The Secretary  
NSW Planning, Industry & Environment

22 September 2021

I refer to the Department's below email of 25 August 2021 regarding the Environmental Impact Statement (EIS) for State Significant Development SSD-15221509 Woolworths Warehouse and Distribution Centre for 'Construction and operation of a warehouse and distribution facility in Wetherill Park for handling chilled and fresh products' located at 250 Victoria Street, Wetherill Park (Lots 1, 2, 3 and 4 DP 781975) in the City of Fairfield Local Government Area (LGA). Submissions need to be made to the Department by 22 September 2021.

JOB NO.	19276
DRAWING NO.	DA2200
REVISION:	C

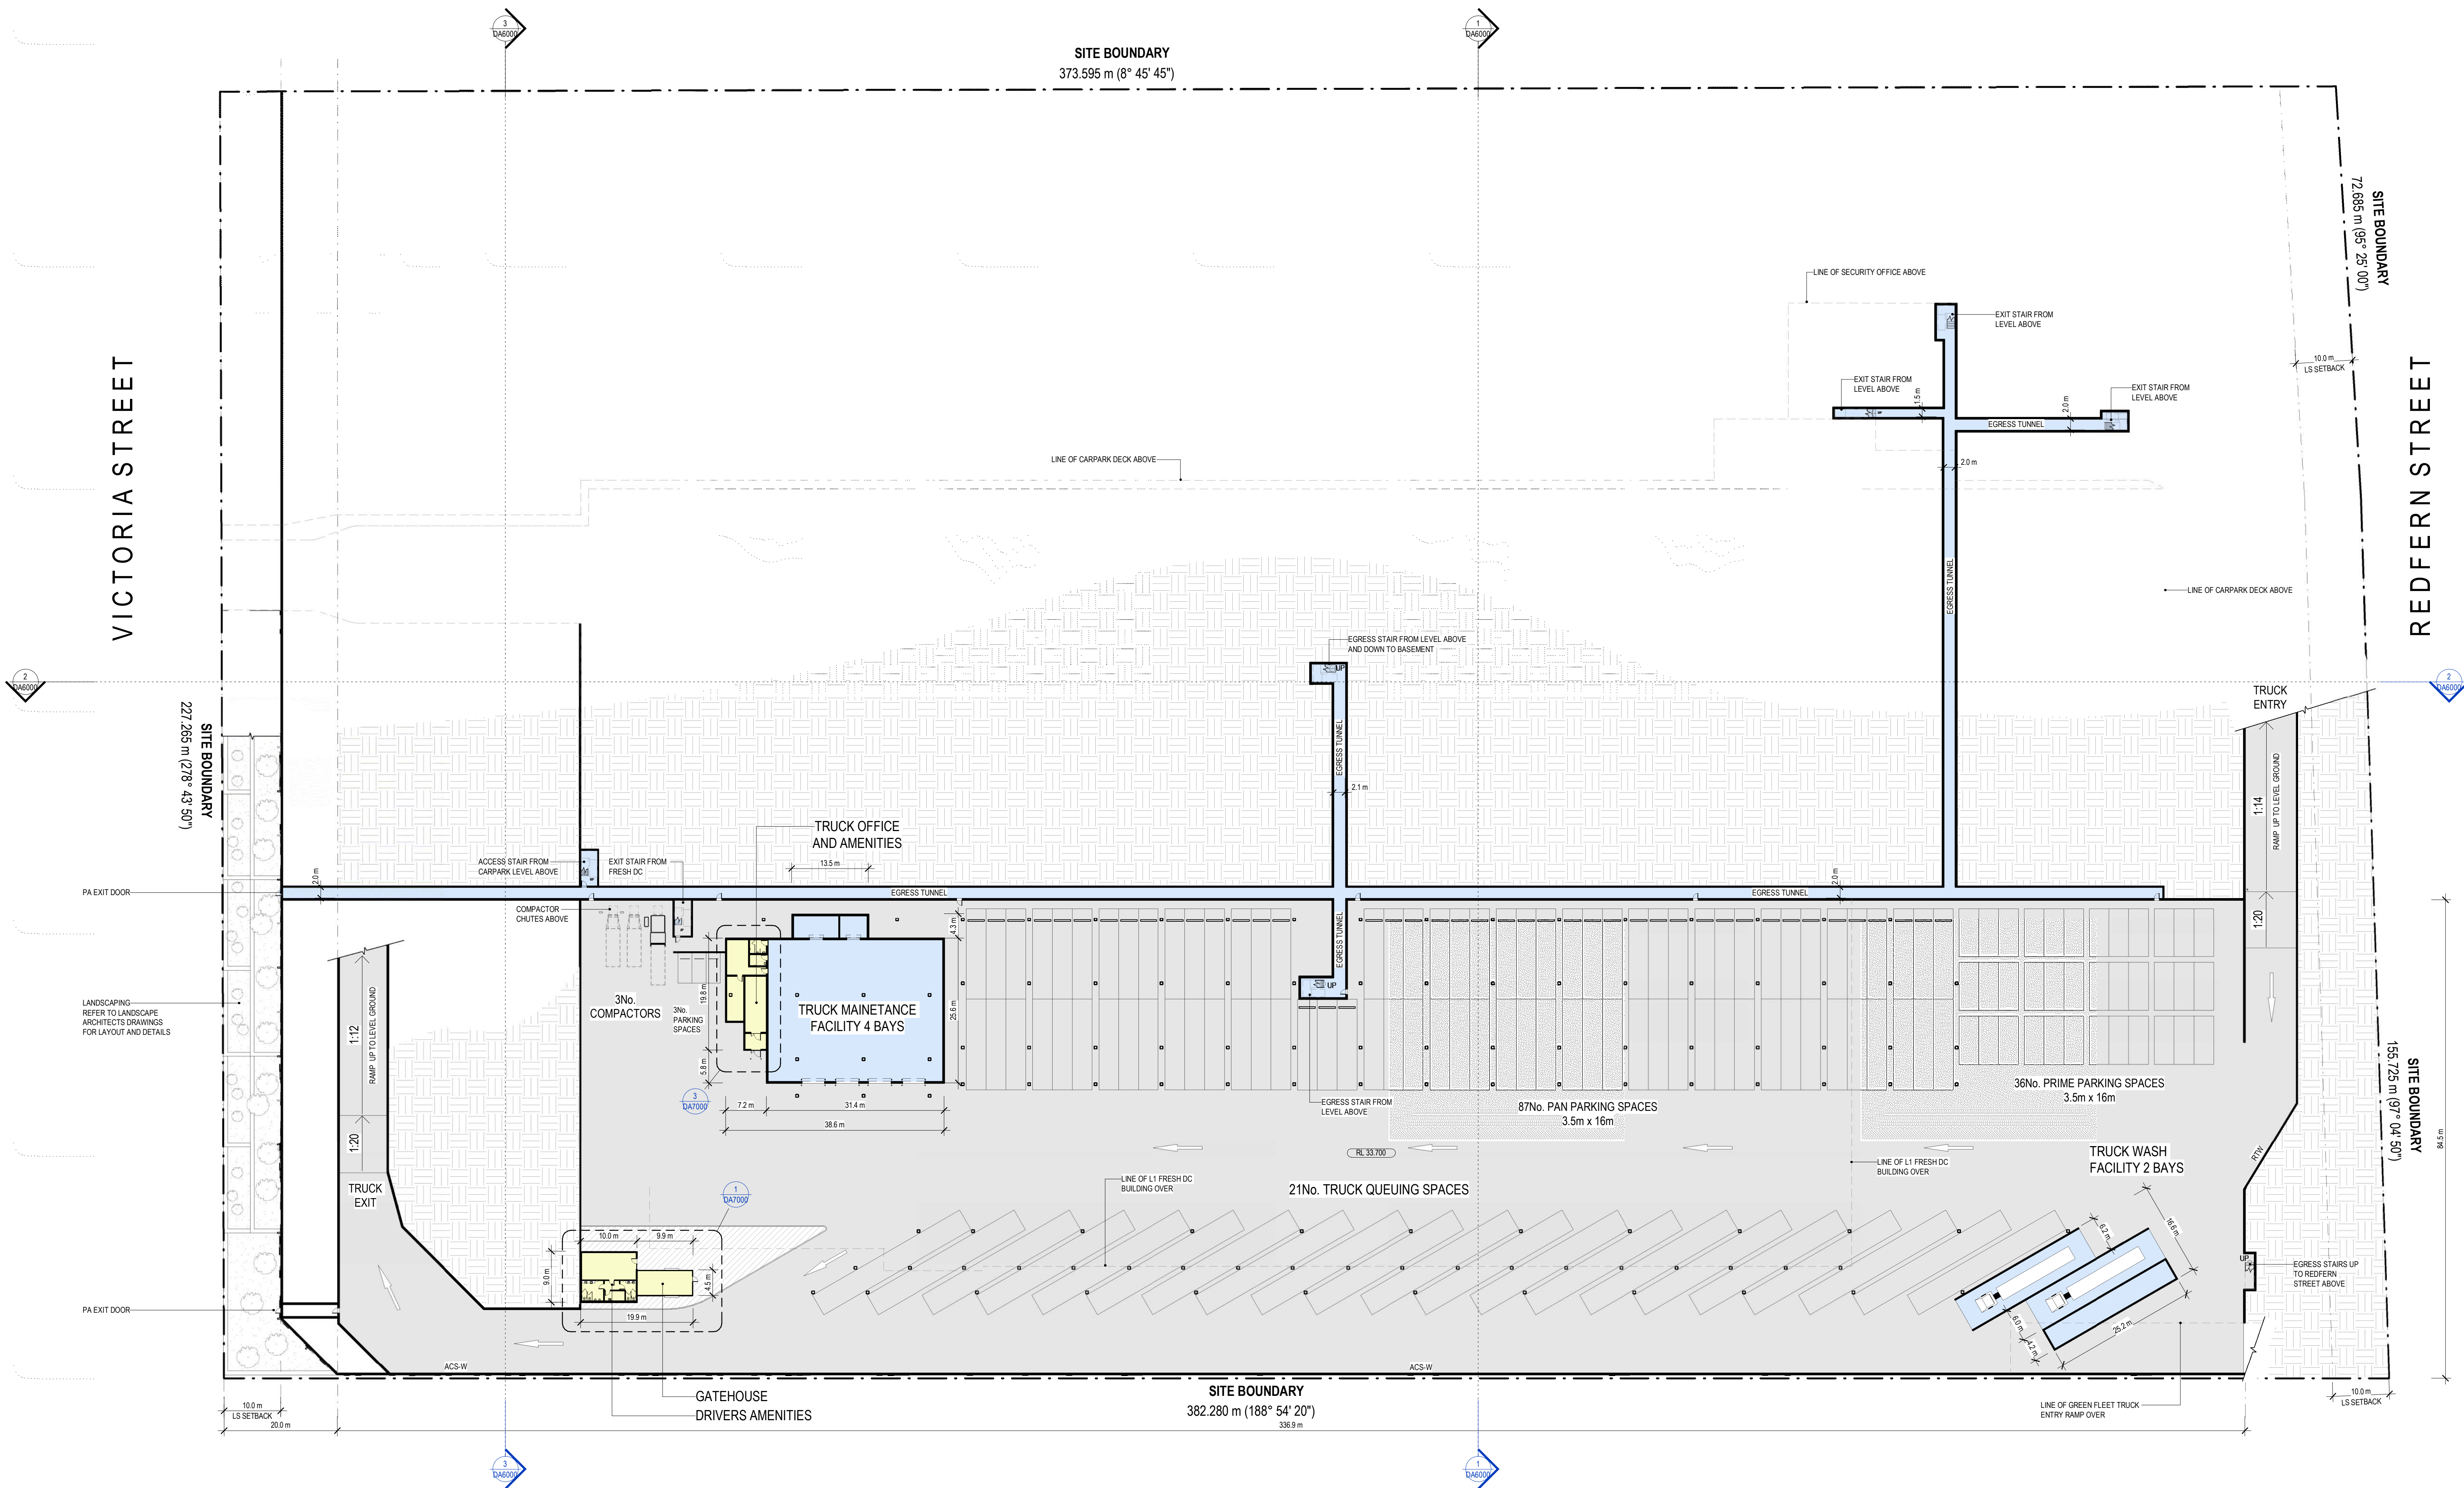
In regard to building over the padmount substations, Endeavour Energy's Mains Design Instruction MDI 0044 'Easements and Property Tenure Rights' includes the following requirements.

The minimum safety requirements padmount substations easements are outlined below and must **always** be met to maintain the safe operation of the network and employees:

- No building overhangs within the six (6) metre airspace above a padmount substation site;
- No construction must occur within the padmount substation / switching station easement;

As shown in the following extract of the Overall Ground Floor Plan the padmount substations are proposed to be located in the south eastern corner of the with frontage to Victoria Street.

Irrespective of the class / division and the quantities, any dangerous goods whether combustible and / or flammable should not be stored near electricity infrastructure and increasing the separation distance as far as reasonably possible is recommended.
